DECISION DELEGATED TO HEAD OF PLANNING

Application No: H11-0261-26 **Applicant:** The RJN Corporation Ltd

Proposal: Replacement of 9 Windows

Location: Churchills, Minerva House 49 West Street Long Sutton

PROPOSED FRONT ELEVATION

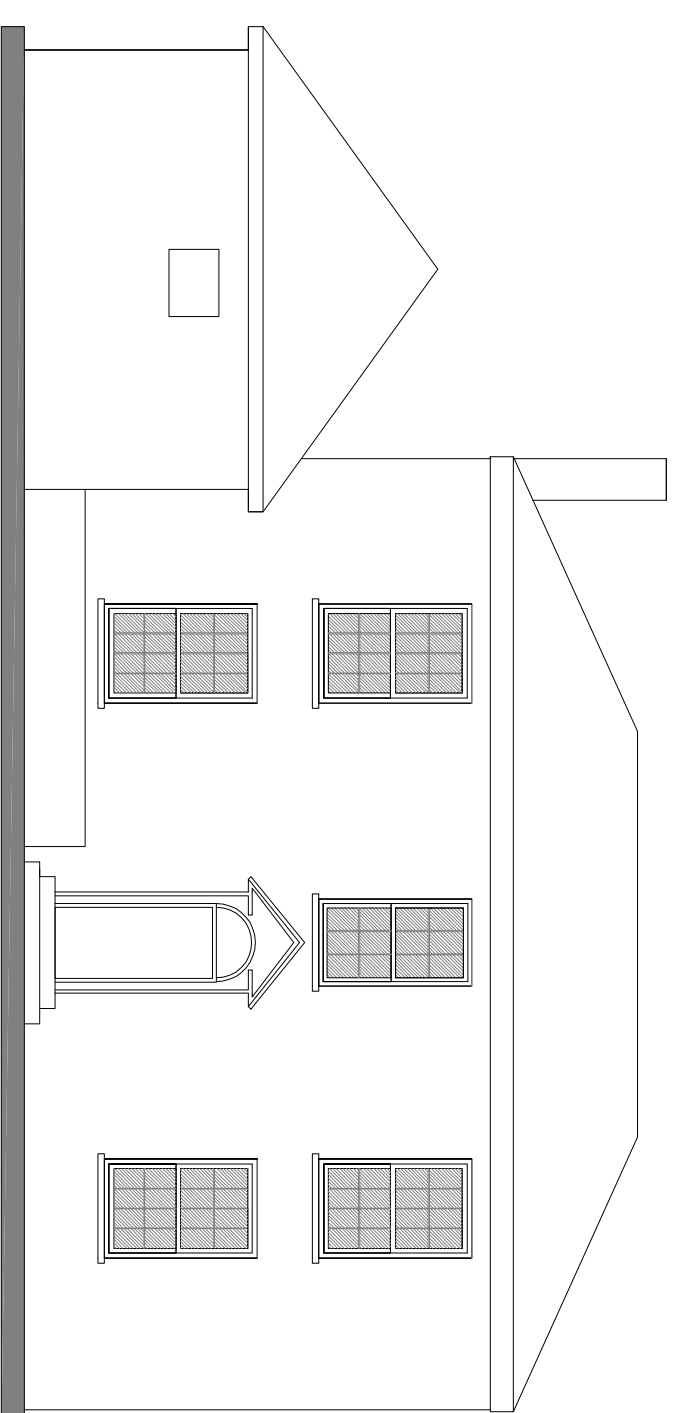
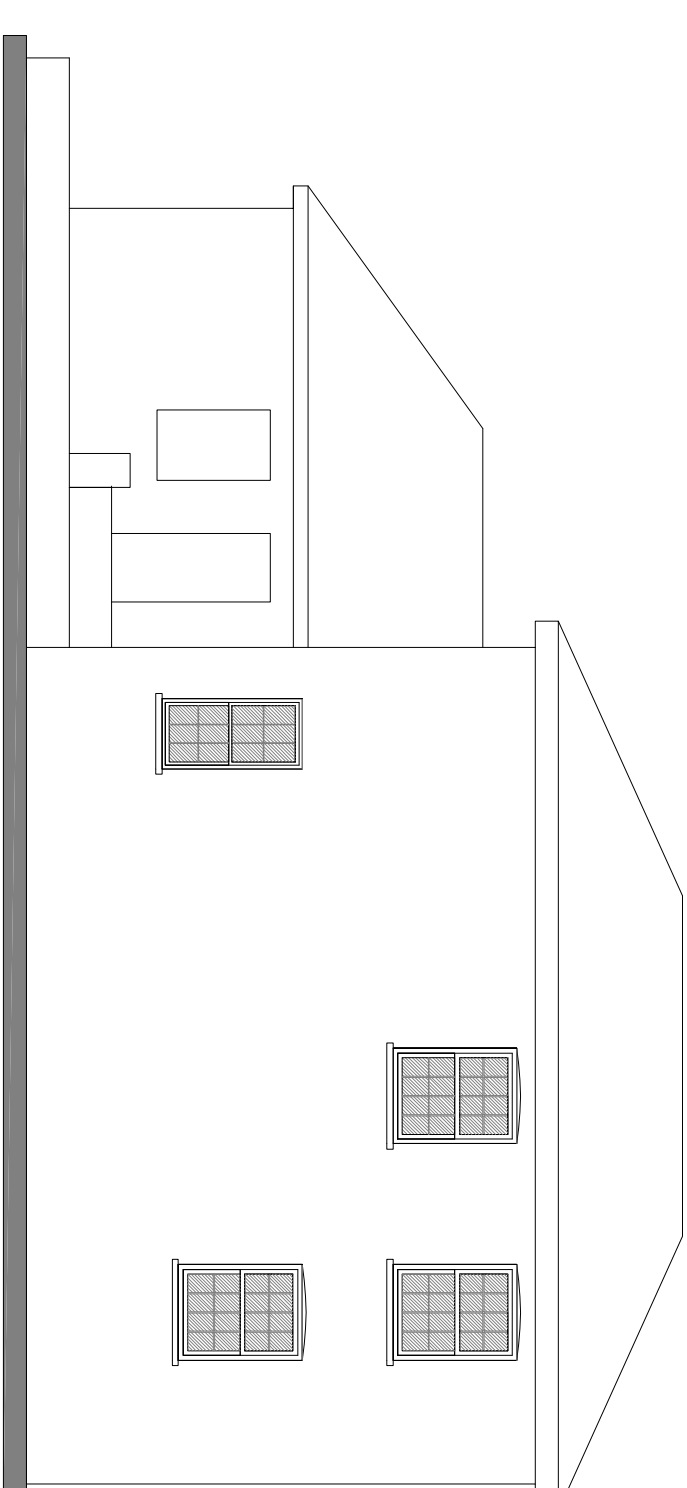
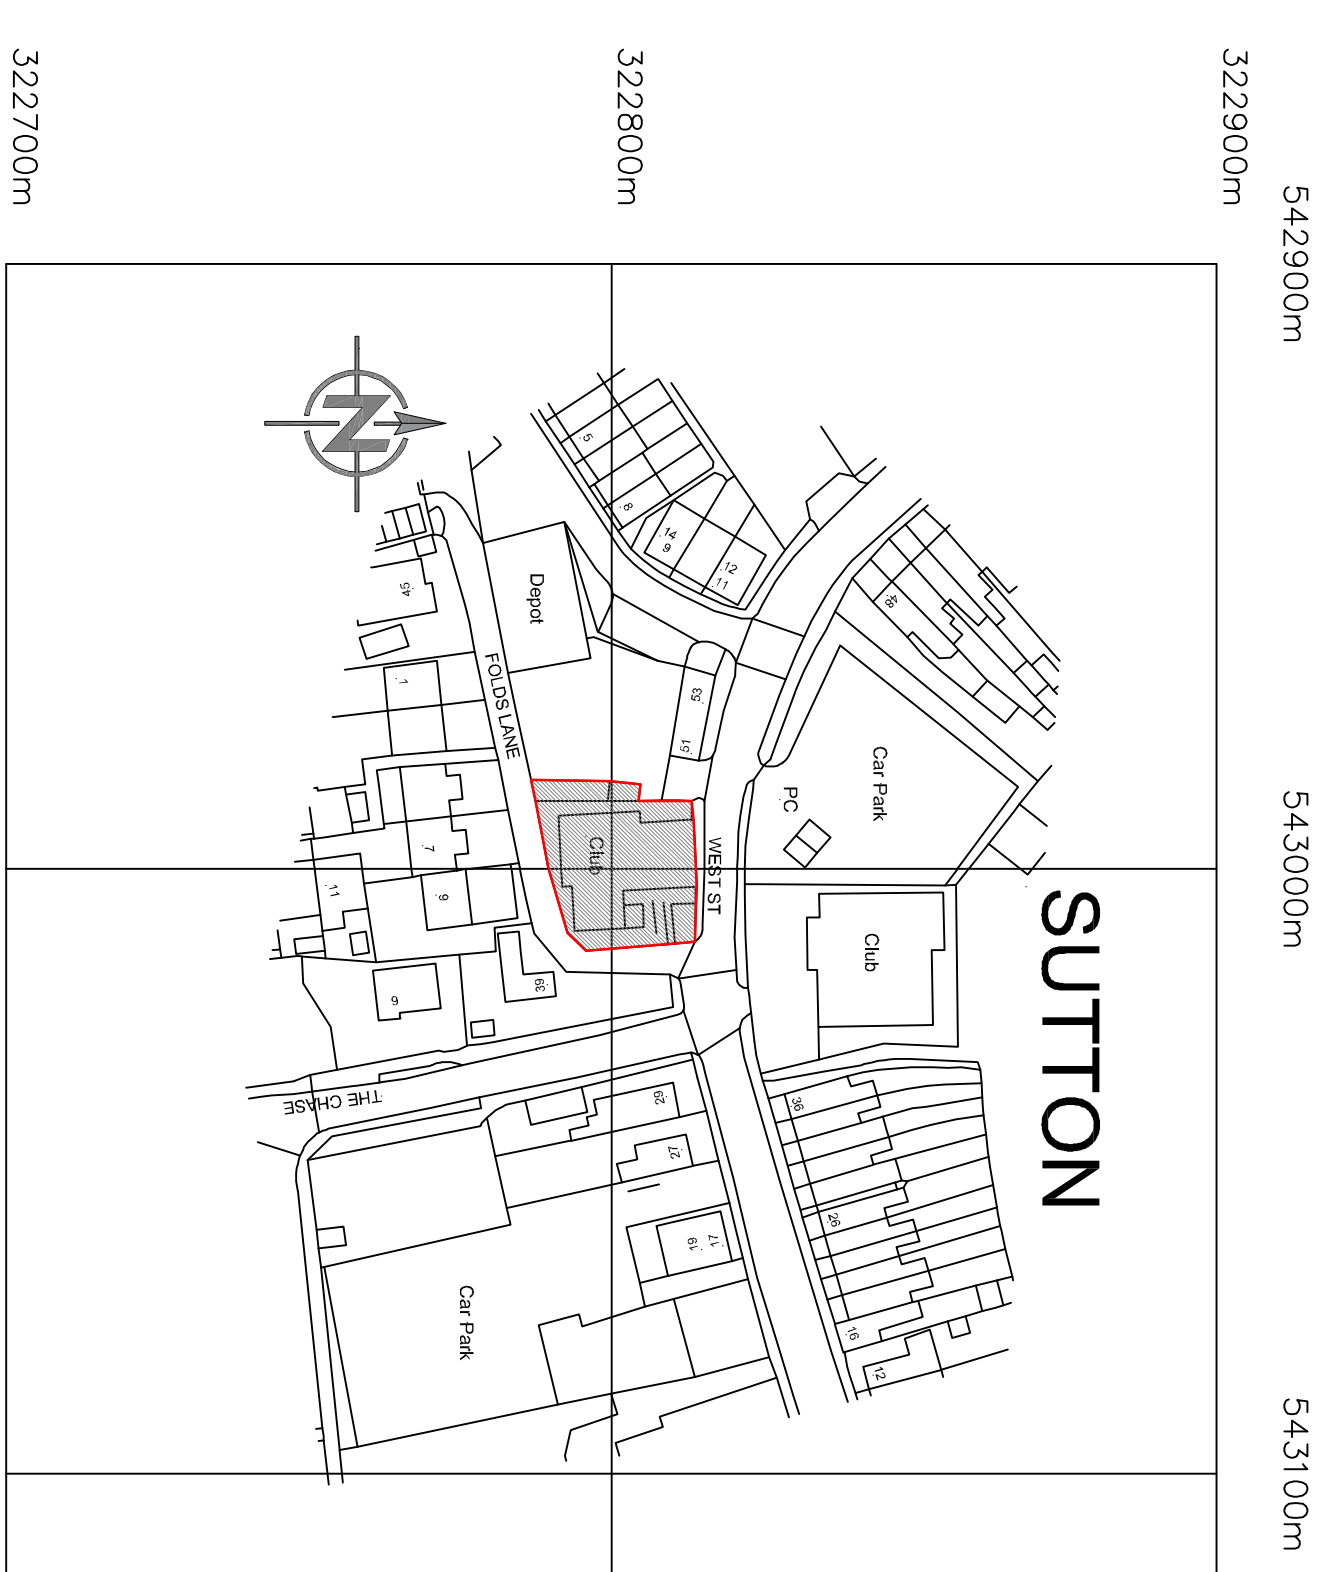
First Response (24 April 2026): I write to confirm my objection to the proposal to replace 9 windows with new double-glazed units. This is because the extant windows that the applications seek to replace appear to be historic or perhaps even original, formed of a traditional single-glazed construction. The latest guidance provided by Historic England within Historic England Advice Note 18 (HEAN18) confirms that replacement of windows with double glazed units can be acceptable, but only where the windows are not important or integral to the overall special interest and character of the listed building. Given that the windows are specifically identified as a feature within the Historic England listing description of the site, and they appear to be of a traditional, perhaps original design and construction, I am not satisfied that this proposal would meet this description of an acceptable form of double-glazing replacement. The development, in accordance with Para. 212 of the NPPF would therefore, constitute a form of 'less than substantial harm' via the introduction of a modern form of glazing, removing the historic character of single glazed panels entirely from the building.

Moreover, typically for the replacement of windows on Listed buildings we require sectional drawings to be provided so that the actual qualities of the proposed windows can be accurately assessed. In this case, only relatively simple details have been provided and so it is not yet even possible to determine the acceptability of the replacements, notwithstanding the other concerns. If the case officer is minded to approve counter to my recommendations, it is absolutely vital that conditions be applied requiring the full details to be provided prior to installation.
